**Consultation Response from KC,
Lead Local Flood Authority**

2026/91721 land at, Greenhill Bank Road, New Mill, Holmfirth, HD9 1ER

**Discharge of details reserved by condition 18 (drainage) on previous permission 2023/90346 for
erection of two detached dwellings**

Date Responded: 16/07/2026

Drainage Layout

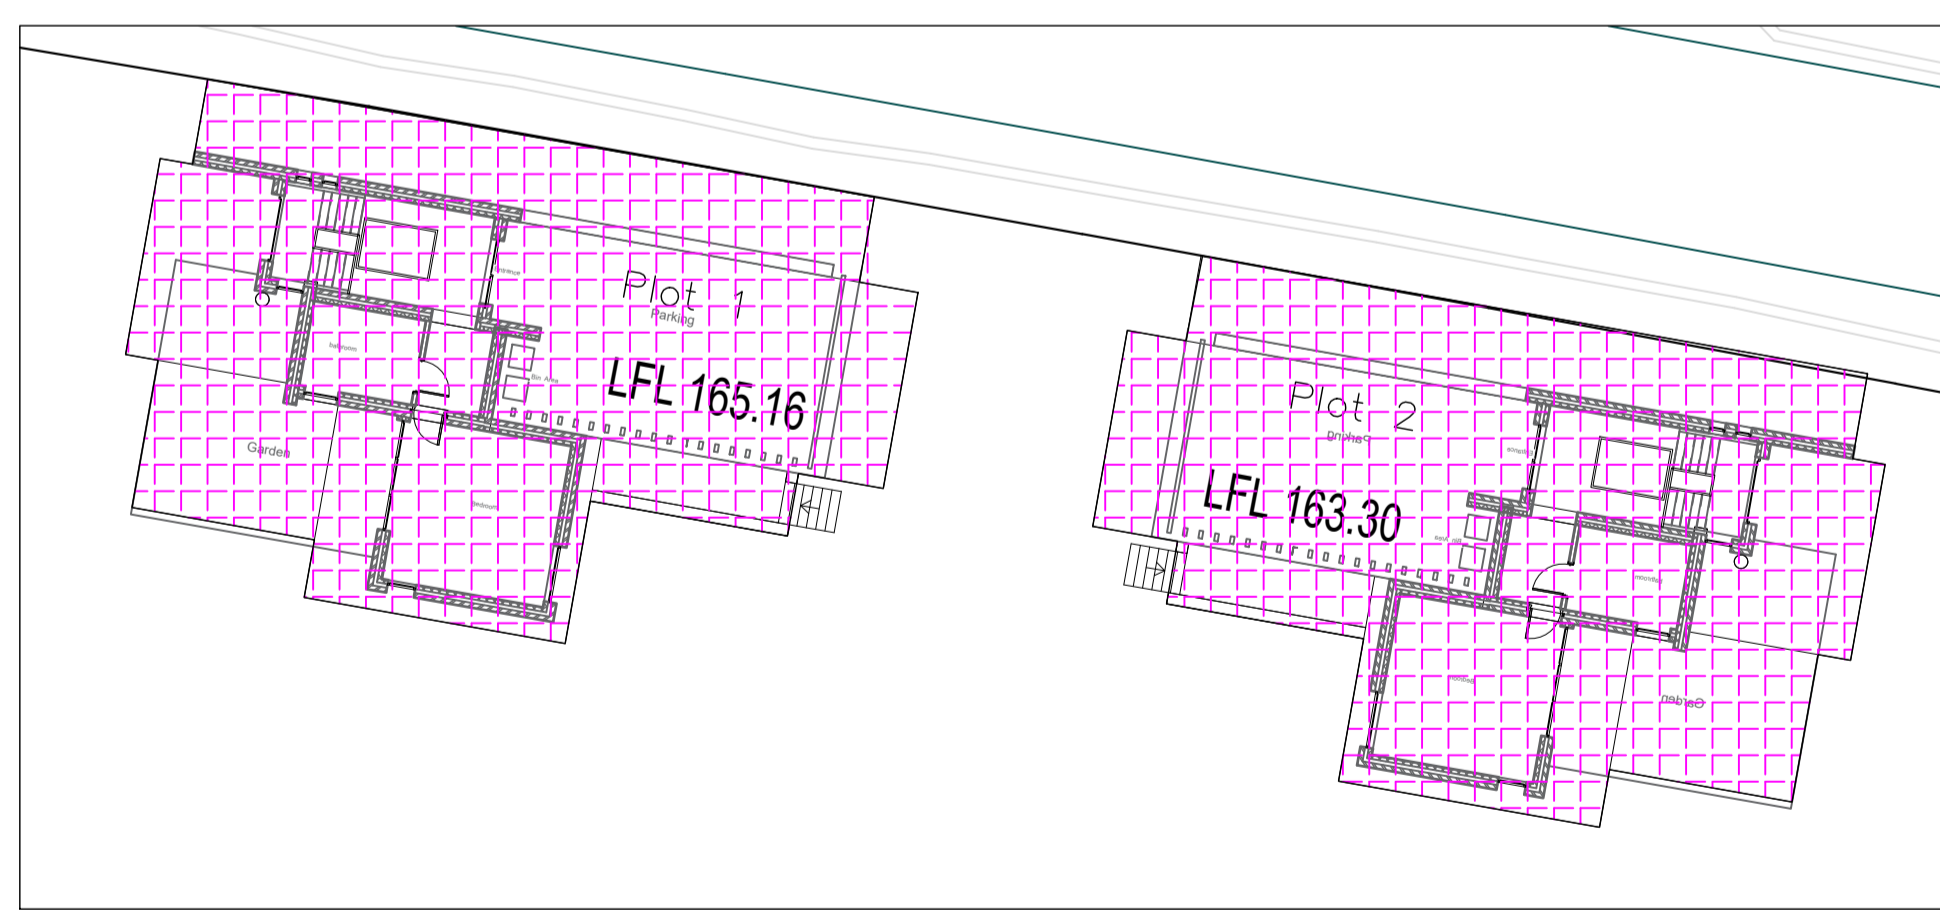
It is noted that the developer is proposing to pump surface water to the public sewer in Greenhill Bank Road. The LLFA do not generally accept private pumping stations as a means of surface water disposal due to the risk of flooding off-site if the pumping station fails (e.g. during power cuts or due to poor maintenance of the pumps). Note that if the pump station was to fail, flood water would flow downhill and into the properties on Moorbrook Mill Drive. No details of who would be responsible for the long term maintenance of the pumping station have been given.

There does not appear to be any reason why the attenuated surface water outfall cannot be connected to the proposed foul sewer from the new buildings. However, this would require Yorkshire Water acceptance.

Therefore, the LLFA cannot discharge Condition 18 until a suitable disposal point for surface water is identified.
